Re: BP#2016-02596 - 58 Alder Street

Can you clarify what the RV on the roof top deck will be used for in terms of actual cooking and/or drink preparation? I have copied Eric Cobb on this email and he will help determine the cities requirements on what the RV will be required to have for kitchen equipment.

AIRSTREAM RV EQUIPMENT PLAN
SCALE 1/2"=1'-0"

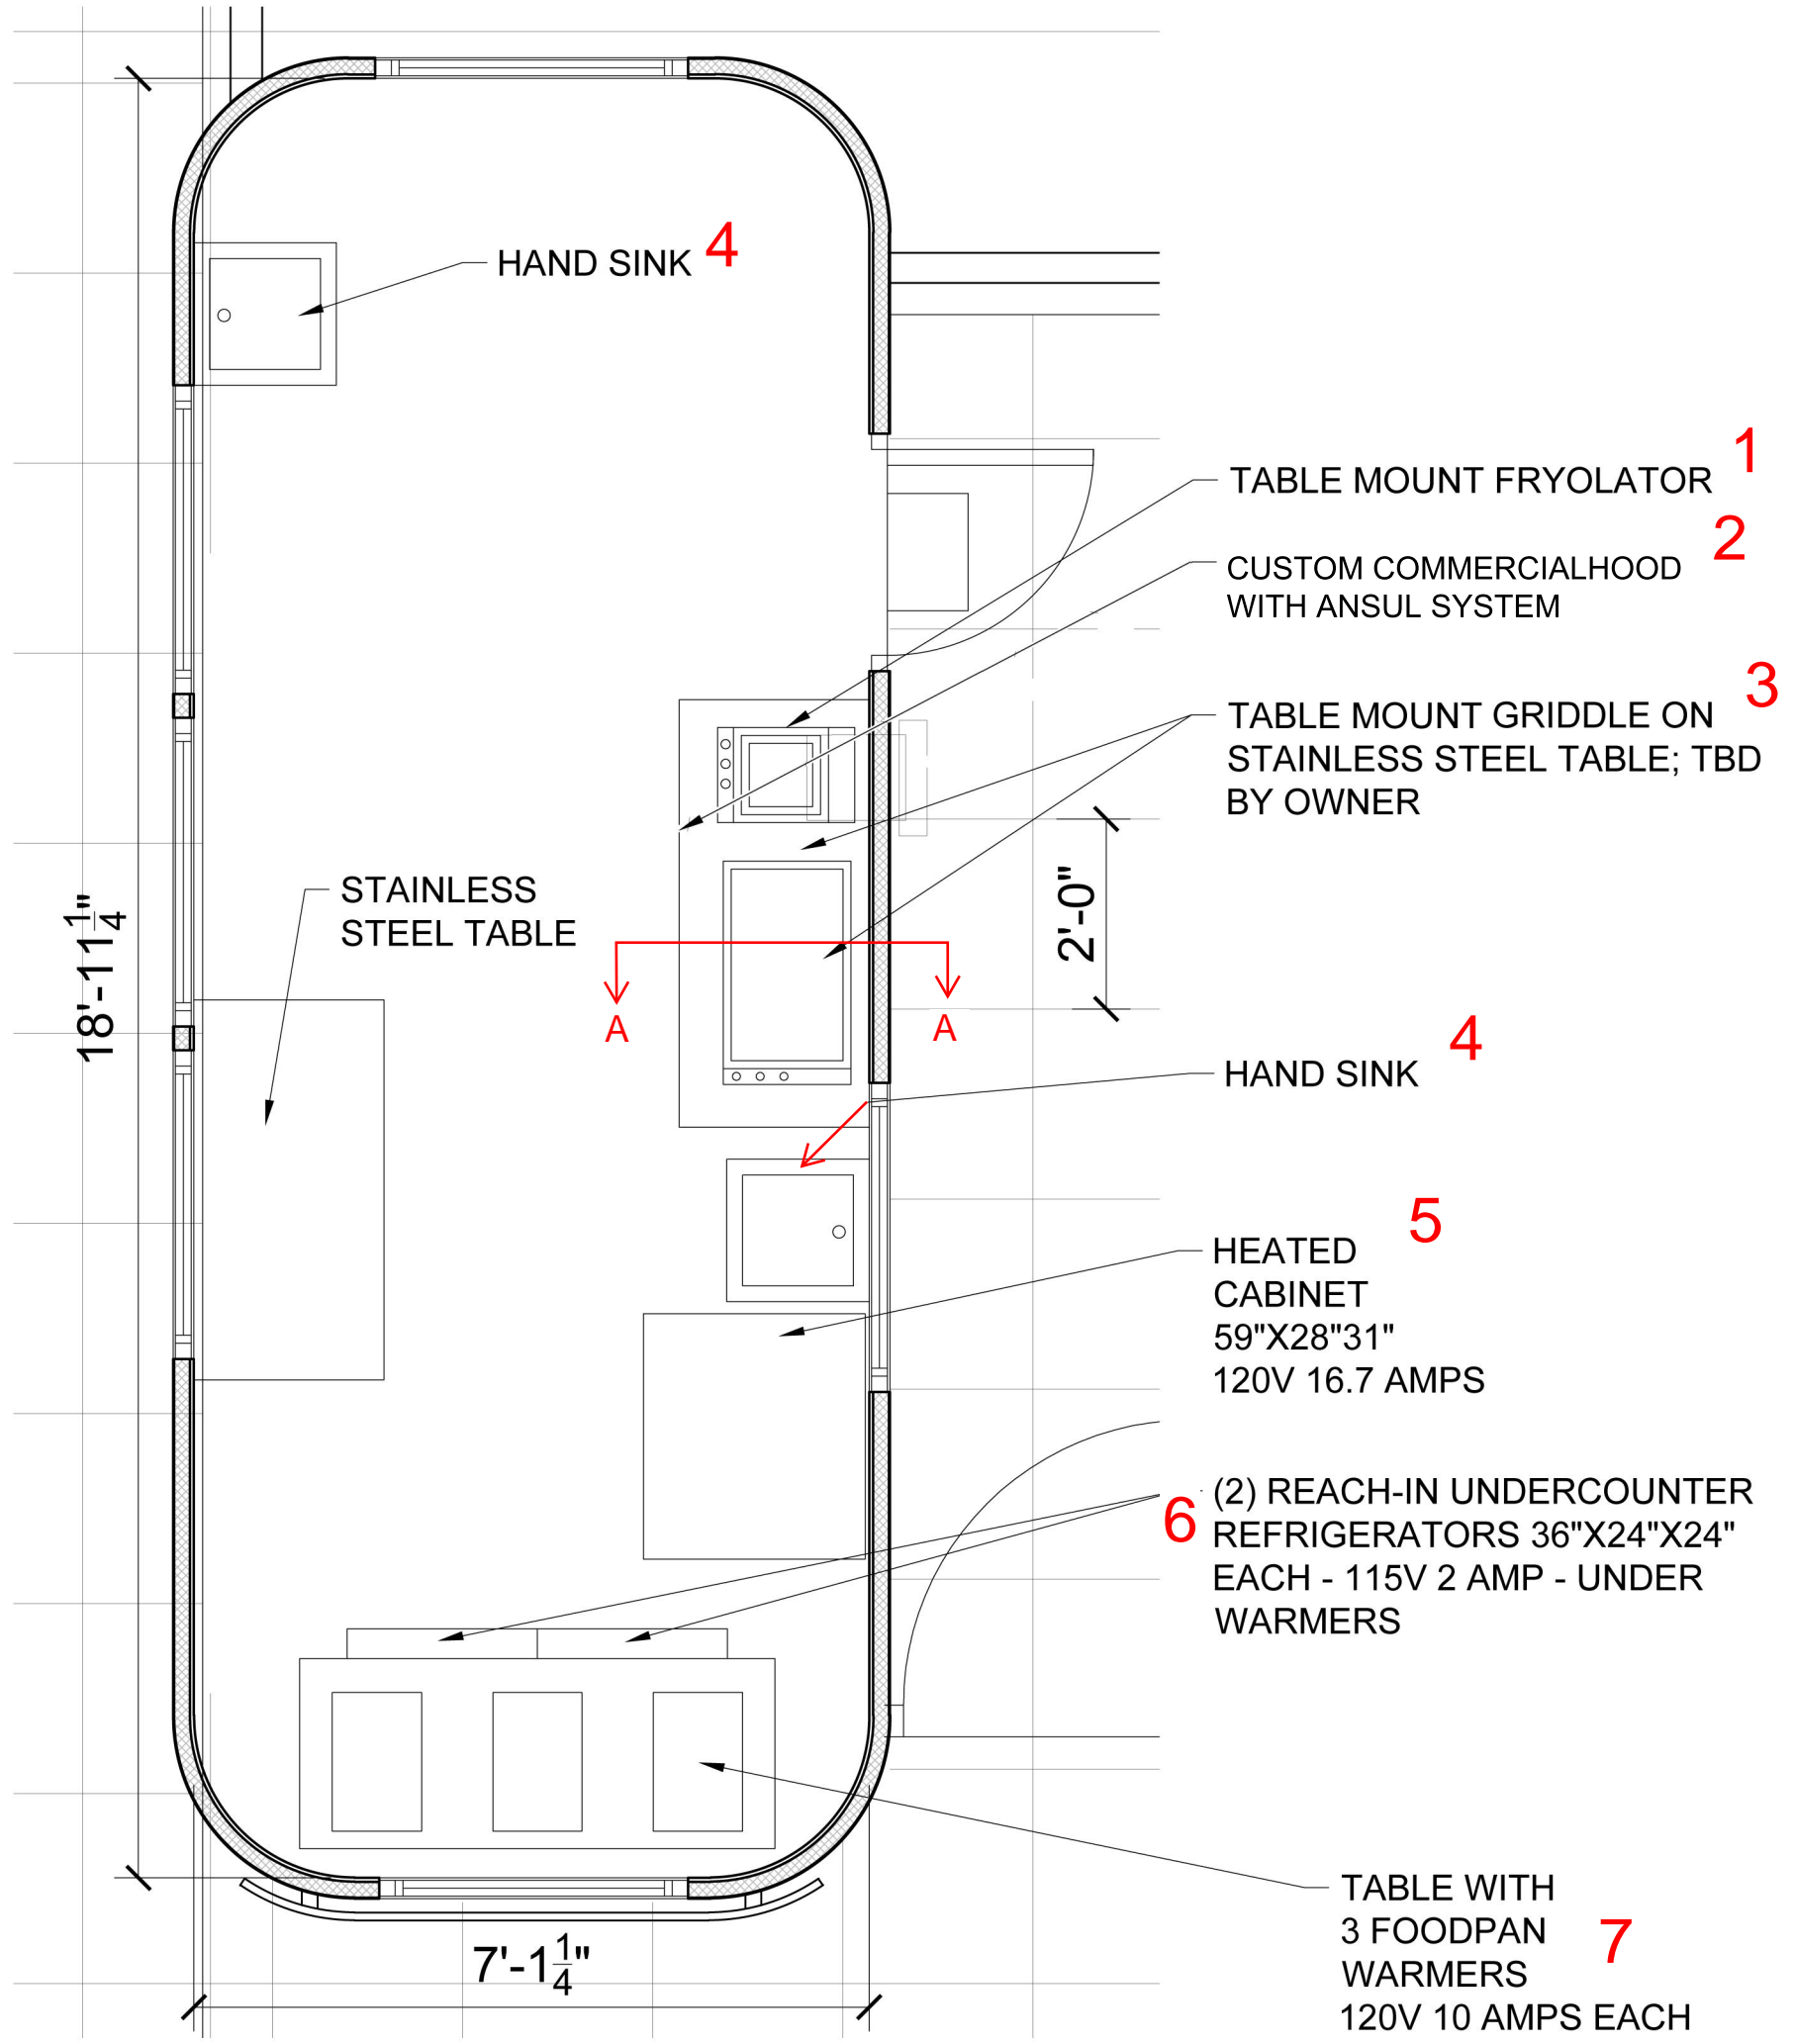
- Will you be preparing food in the RV?
- If so, what kind of food prep are you anticipating?
- Will dishes be washed in the RV?

If the food preparation, cooking, and dish washing is going to be done in the main kitchen, only a hand wash sink would be needed in the RV. They would also need to have access to a designated prep sink for produce washing and a mop/utility sink somewhere in the establishment as well.
